# ITEM 1.3(a)

**Issue/ Objection:**  
Natural Ventilation

PROJECT  
 85 Harrington Street  
 The Rocks  
 GOLDEN AGE & HANNAS THE ROCKS

TITLE  
**RESPONSE TO DoPE  
 ITEM 1.3(a)**

TITLE
**Diagrams
 Cross Vent**

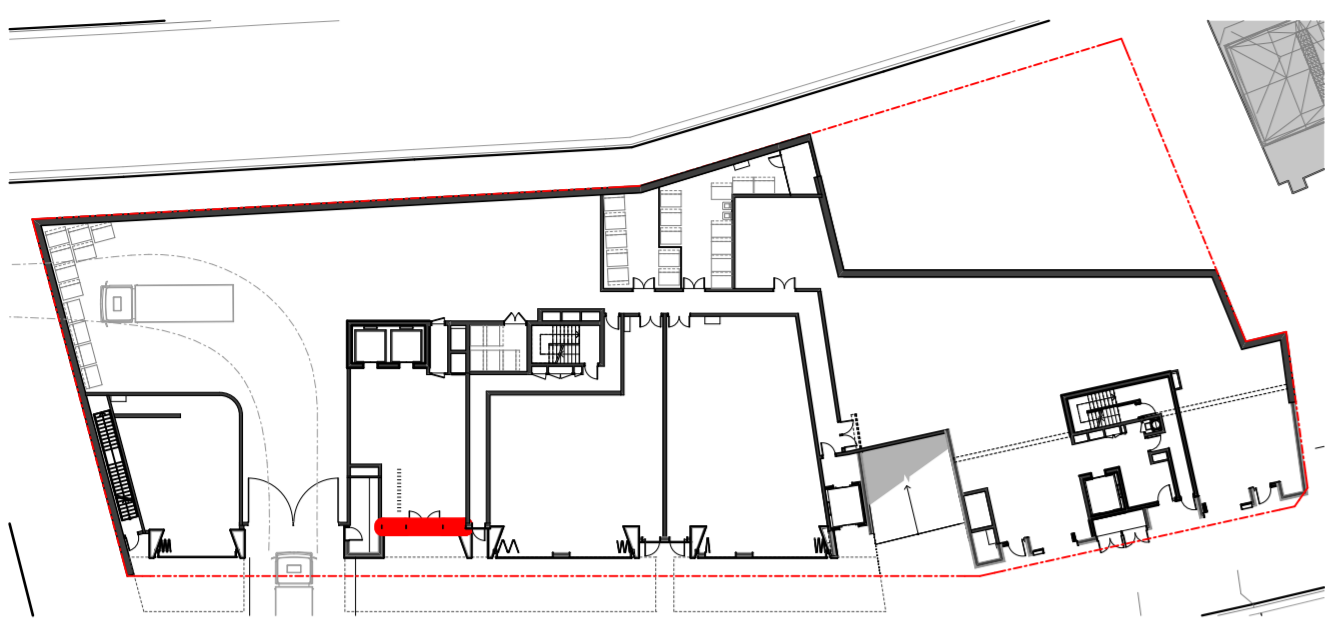
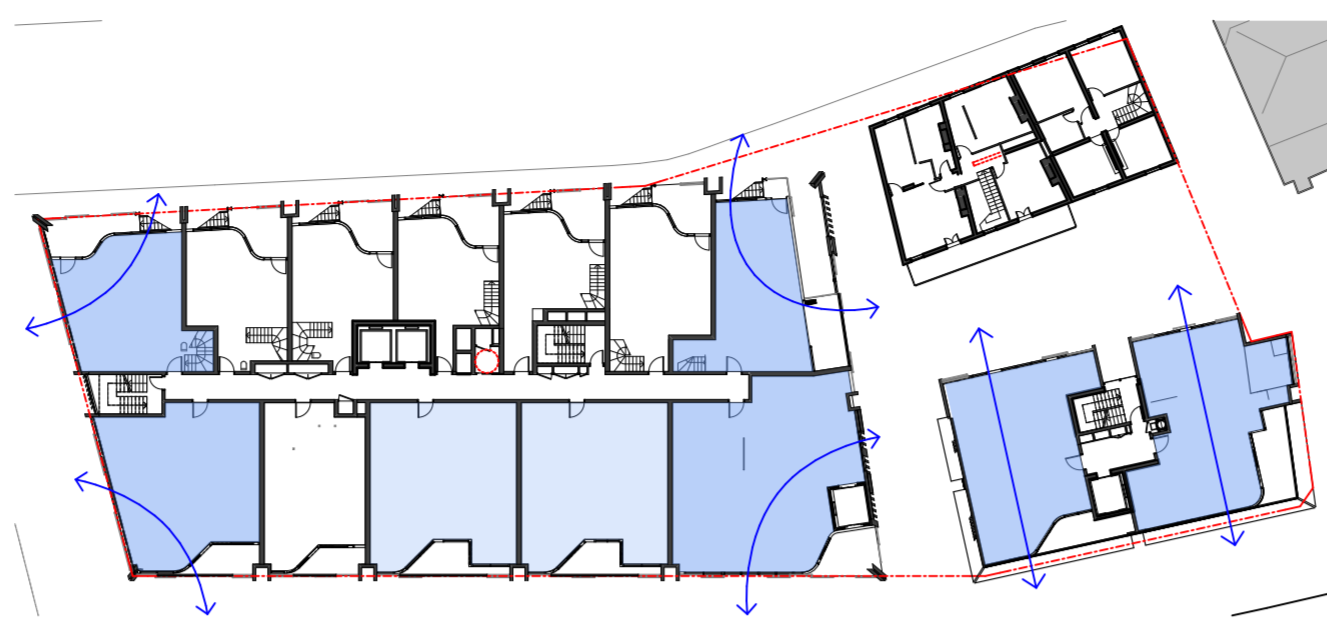
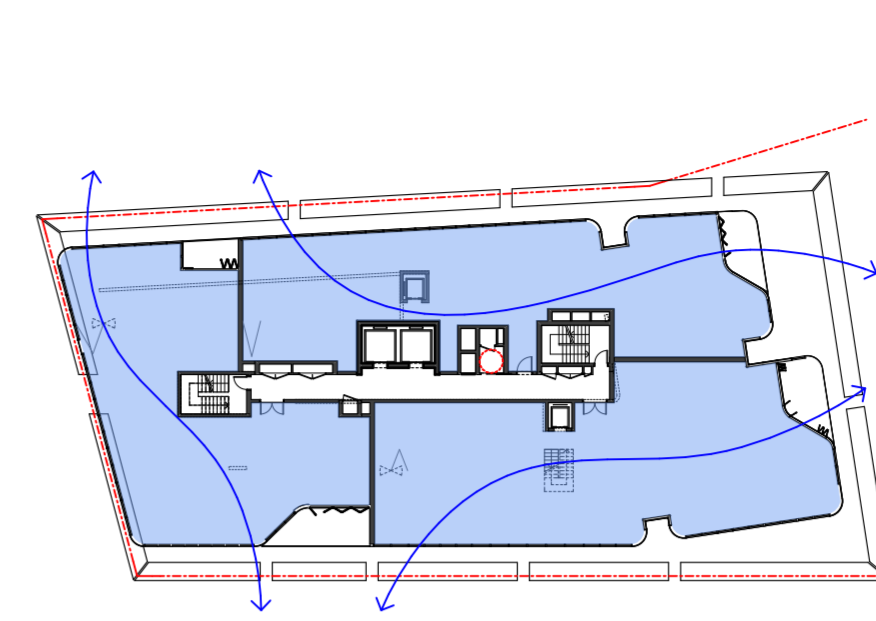
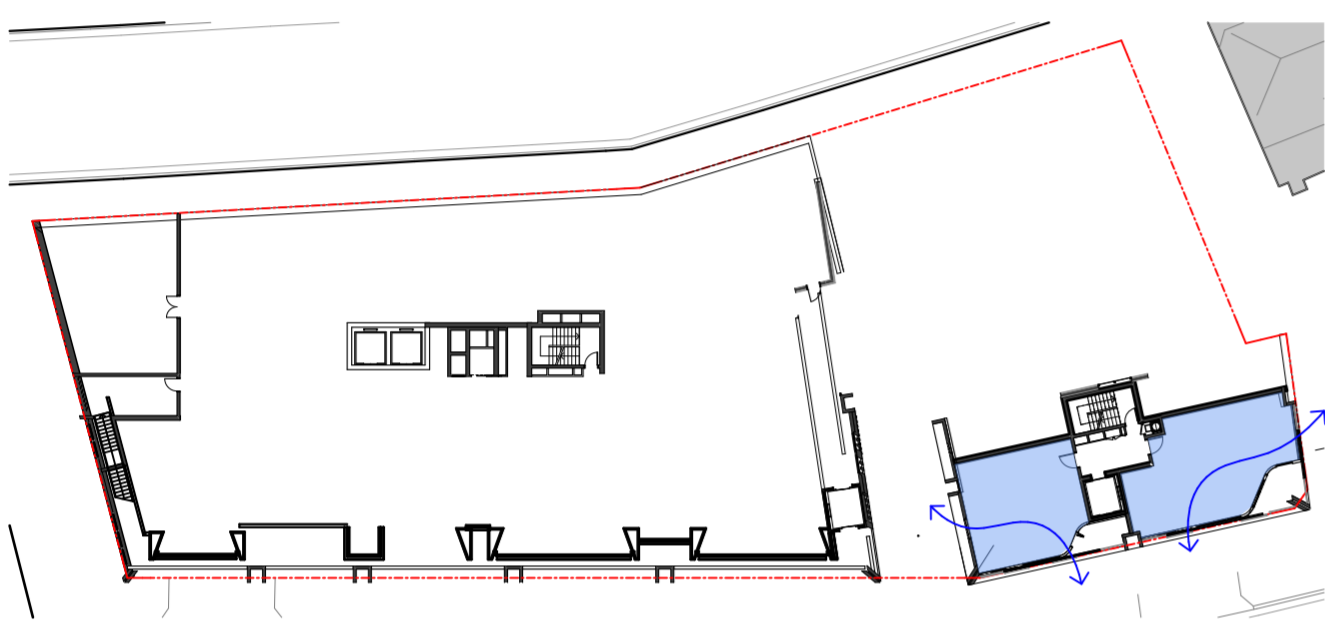
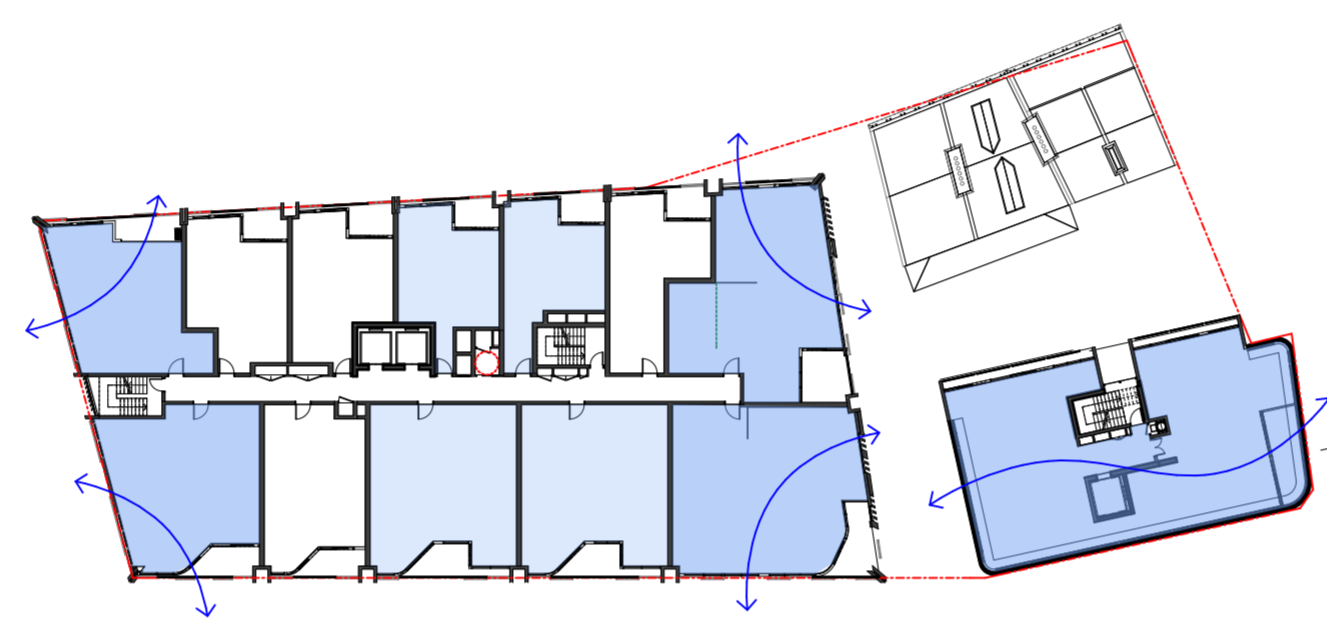
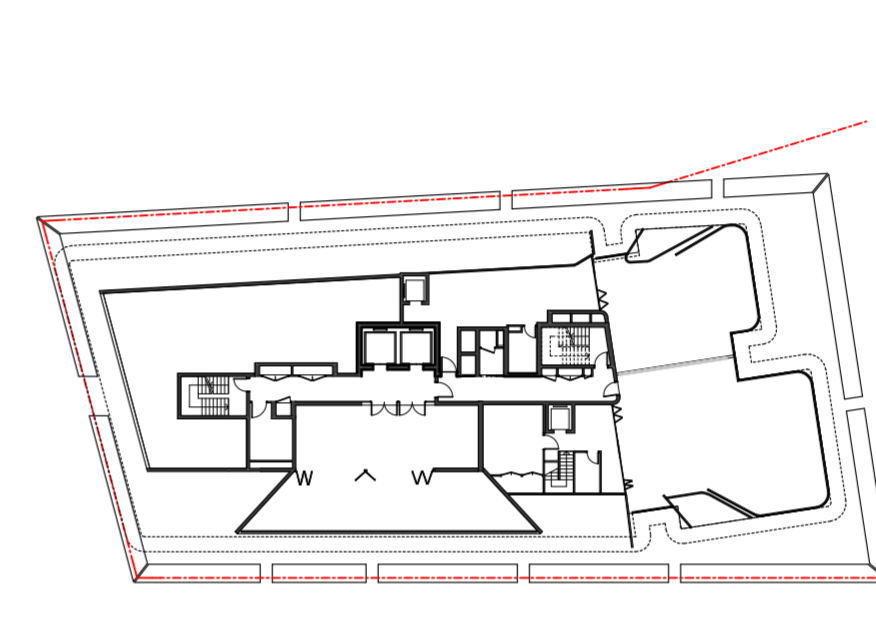
**Description:**  
The proposal includes the five single aspect maisonette units as achieving natural cross ventilation. Further evidence is required demonstrating how these units achieve natural cross ventilation. Consideration should also be given to alternative dieting solutions for non-cross ventilated units to improve natural ventilation.

**Response**  
29 Apartments achieve compliance as per the apartment design guide's (ADG) definition of natural cross ventilation. 5 Apartments achieve cross ventilation as detailed in qualitative assessments undertaken by ARUP. Refer to all additional information prepared by ARUP.
